From: Graeme Means <gmeans@highmesacg.com>
Sent: Thursday, December 02, 2021 4:26 PM
To: Biazar, Shahab
Cc: Justin Schara; Trujillo, Timothy R, NMDOT; Aaron Zahm; Brian Verardo
Subject: FW: [EXTERNAL] RE: Los Altos Park - Phase I (K20D037) Drainage Comments

I have no further questions regarding the Los Altos Park development. The site has minimal impact to the existing drainage runoff condition and will address the new MS4 requirements. This email will serve as NMDOT's approval. Please let me know if the plan should change or if there are any questions regarding this approval.

I have no issues with the hydrology. The only remaining comments are from our meeting. No HDPE as a connection to NMDOT inlets and could you provide a floatable screen (chain link fence buried 1') in the existing swale to the eastern NMDOT 54" culvert connection to the arroyo. This can be placed at the end of the concrete valley gutter. I'll see if I can find a detail for this.

CHAIN LINK FENCE 'FLOATABLES SCREEN'

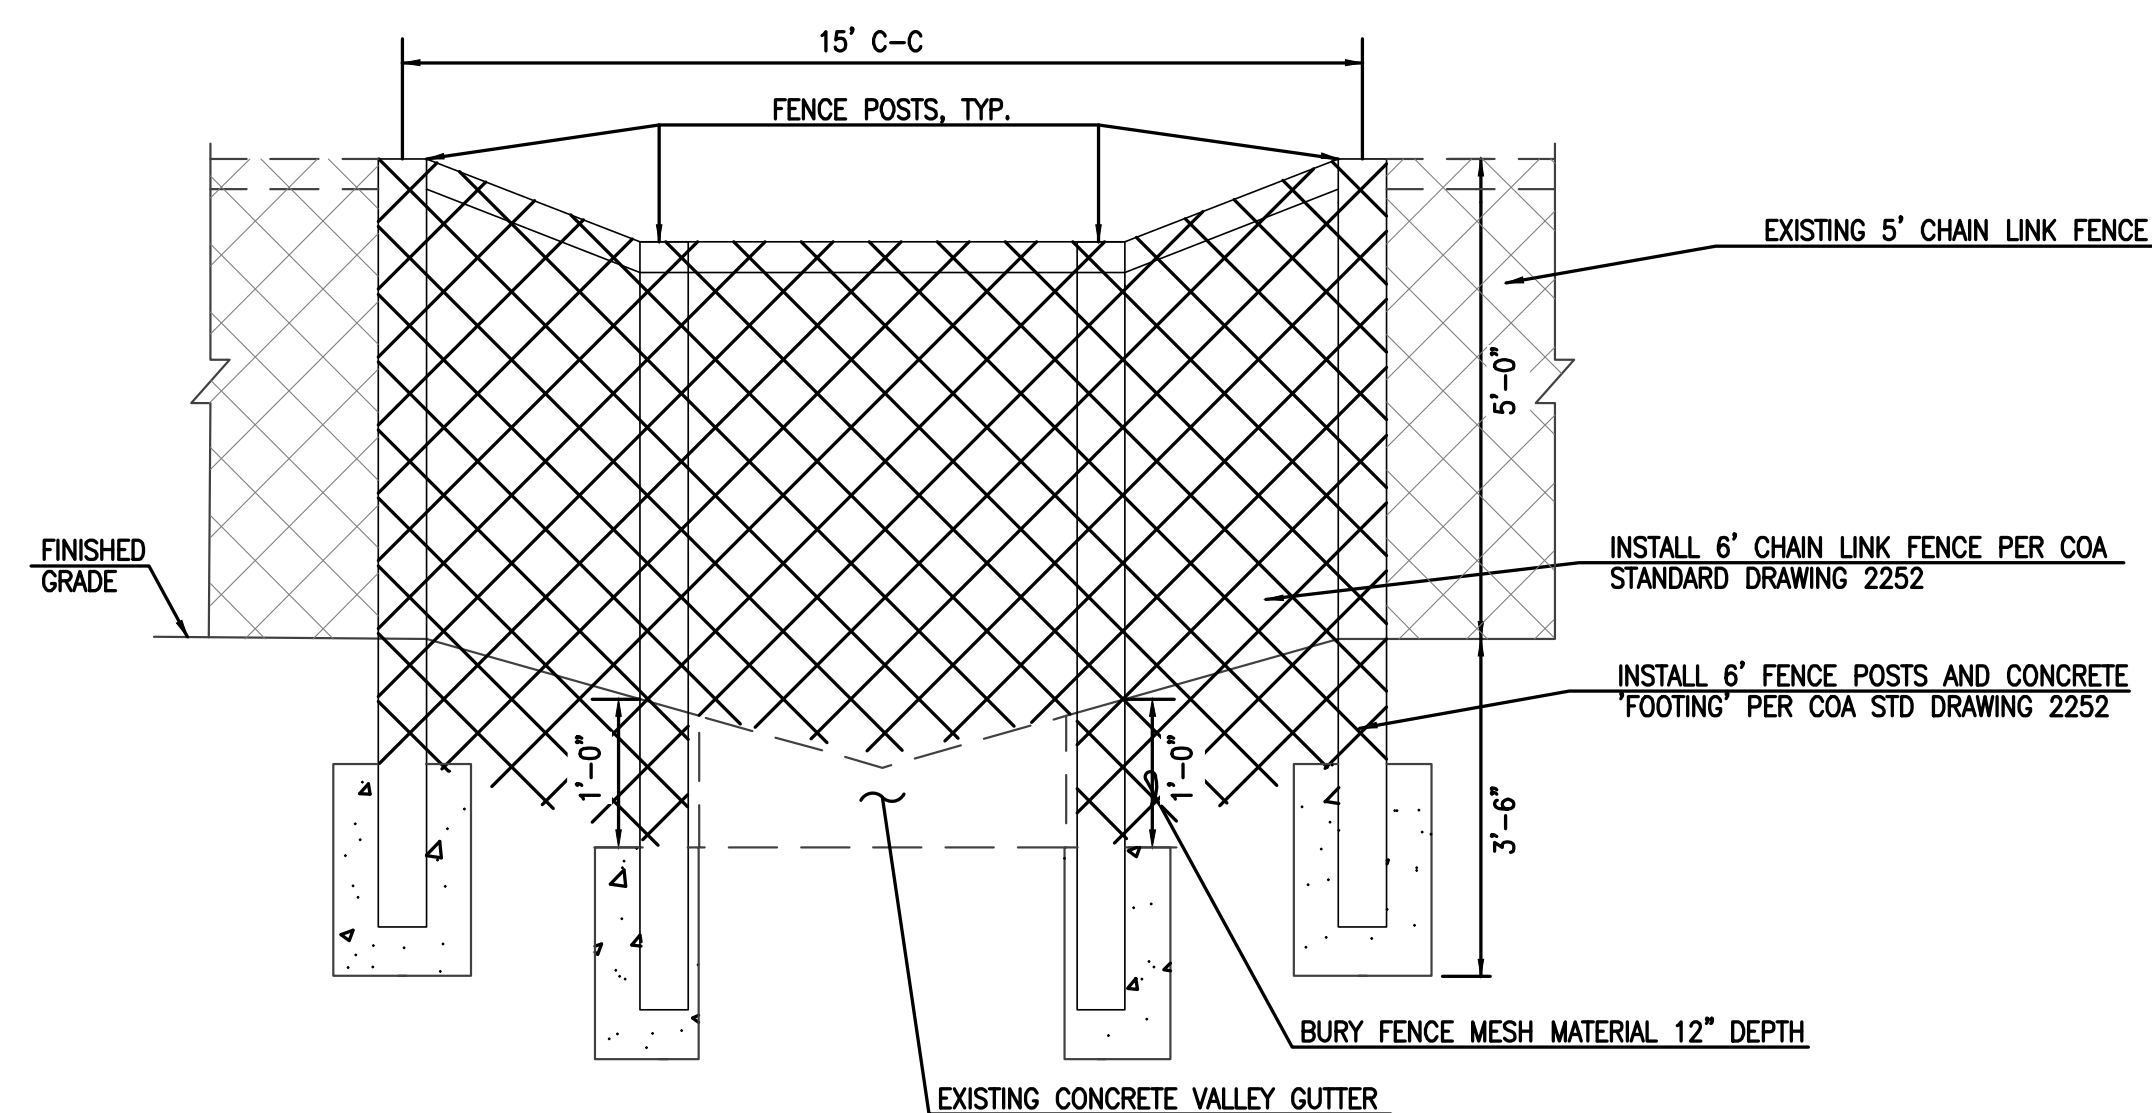
Can the screen be placed at the end of the valley gutter in COA property? Any debris would be generated in City jurisdiction.

The detail looks good! I also have no further comments on the plans. For my own records, does COA have a standard detail for the snout? Please let me know if any thing should change.

I reviewed this with Graeme and we believe we can do this. The existing valley gutter stops even with the fence line, so instead of a 'V' shape, we are thinking of replacing a couple panels of the existing fence line with a detail similar to the sketch below, where the fence would be buried on either side of the valley gutter and then straddle gutter itself.
